KIRKLEES METROPOLITAN COUNCIL DEVELOPMENT & MASTER PLANNING SERVICE

DELEGATED DECISION FOR PRIOR APPROVAL FOR CHANGE OF USE FROM COMMERCIAL, BUSINESS AND SERVICE USES TO DWELLINGHOUSES

Reference no. 2023/CL/93645/W

Site Address	1st & 2nd floors, 9-13, Market Walk, Huddersfield, HD1 2QA
---------------------	---

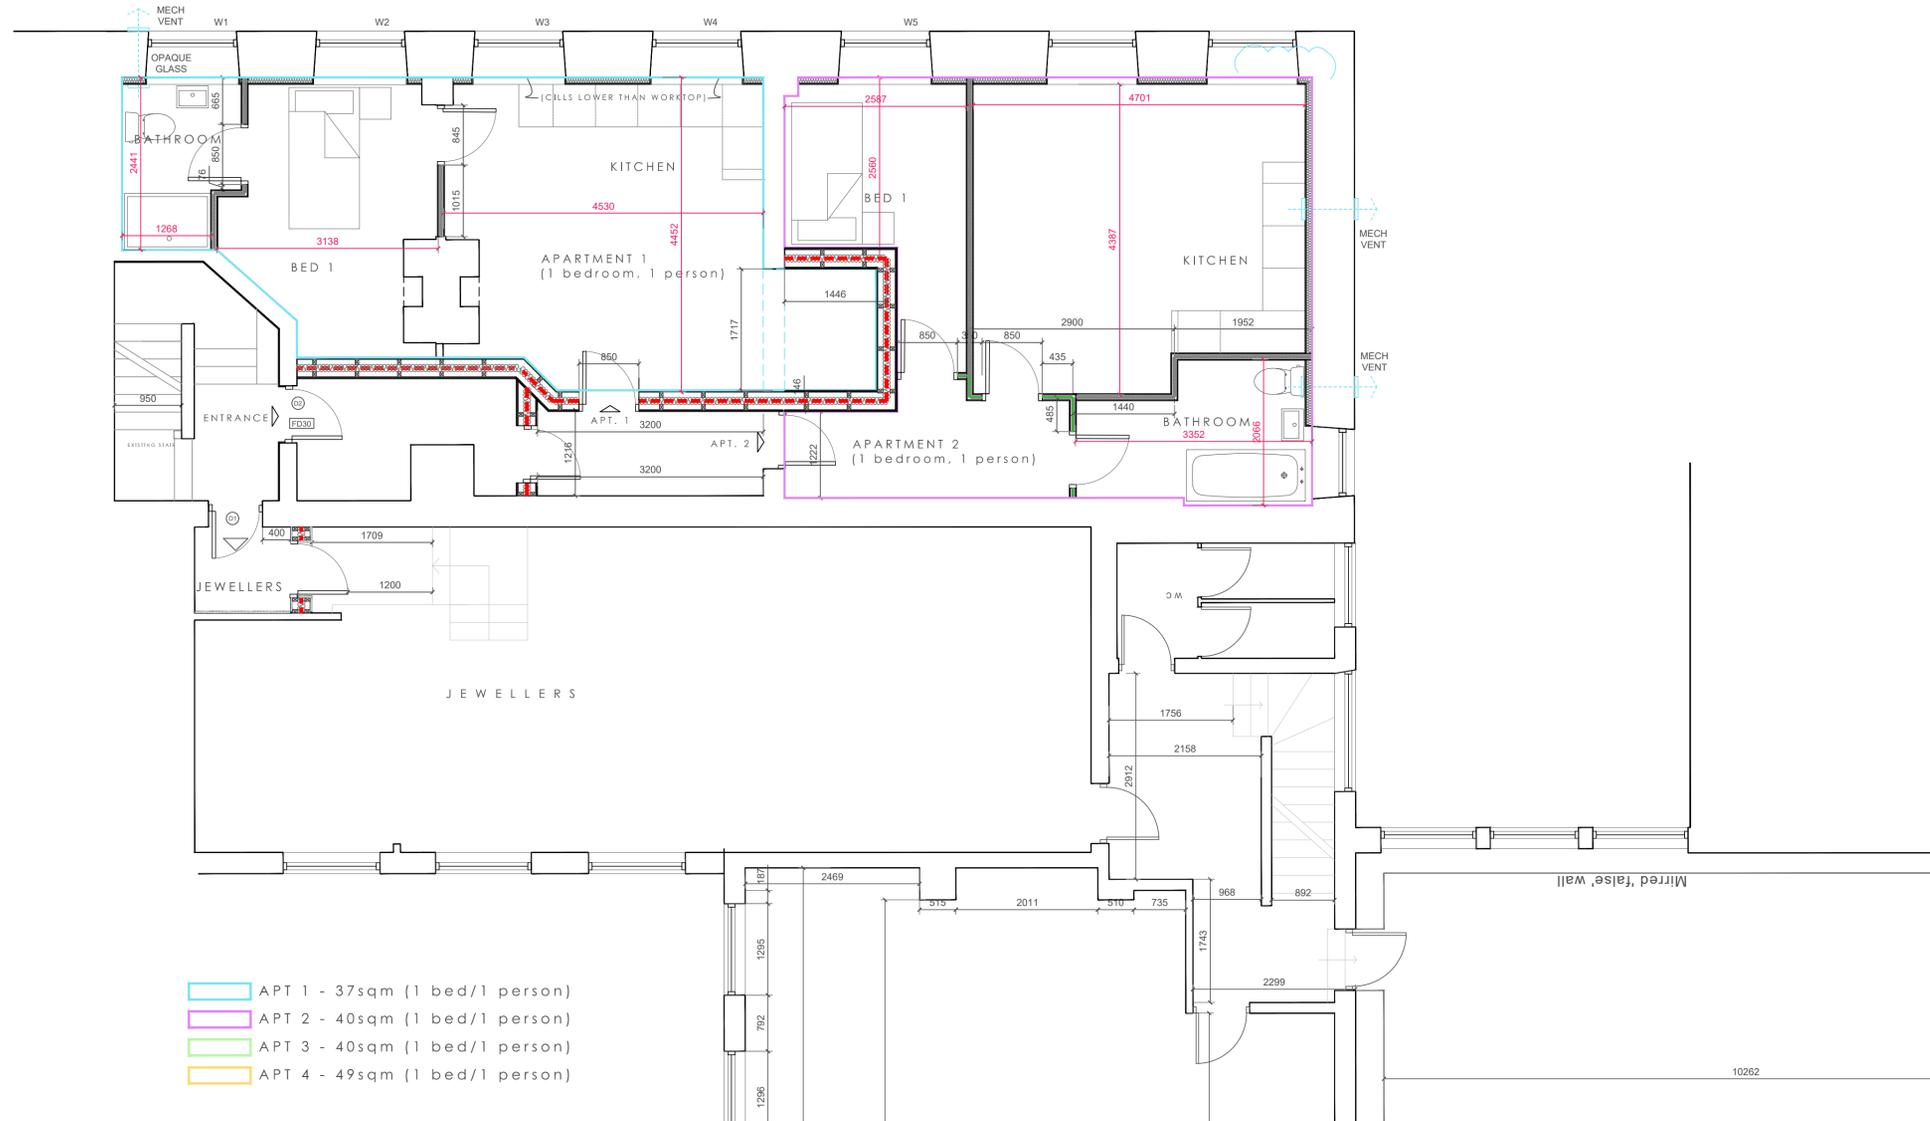
Apartment 1 is proposed to be a one bedroom first floor flat. The Technical Housing Standards document states that a one-bedroom flat for one person

(minimum assessed) one storey should be at least 37 or 39 square metres dependant on whether the bathroom has a shower. In this instance, the internal accommodation is proposed to be 37 square metres which is confirmed by annotation on the submitted plans. Therefore, providing that the flat is occupied by one person only, this flat would meet the required space standards.

Apartment 2 is proposed to be a one bedroom first floor flat. The Technical Housing Standards document states that a one-bedroom flat for one person (minimum assessed) one storey should be at least 37 or 39 square metres dependant on whether the bathroom has a shower. In this instance, the internal accommodation is proposed to be 40 square metres which is confirmed by annotation on the submitted plans. Therefore, providing that the flat is occupied by one person only, this flat would meet the required space standards.

In terms of natural light, the submitted floor plans demonstrate that all habitable rooms within all four apartments would benefit from at least one window and therefore it is considered that all habitable rooms would be provided with adequate natural light to allow an acceptable standard of amenity of future occupants and would therefore accord with the criteria.

1. Notwithstanding the submitted details, Apartment 1 shall not be occupied by more than 1 no. person unless space standards for additional occupants as defined by the National Described Space Standards are achieved.

1. Notwithstanding the submitted details, Apartment 2 shall not be occupied by more than 1 no. person unless space standards for additional occupants as defined by the National Described Space Standards are achieved.
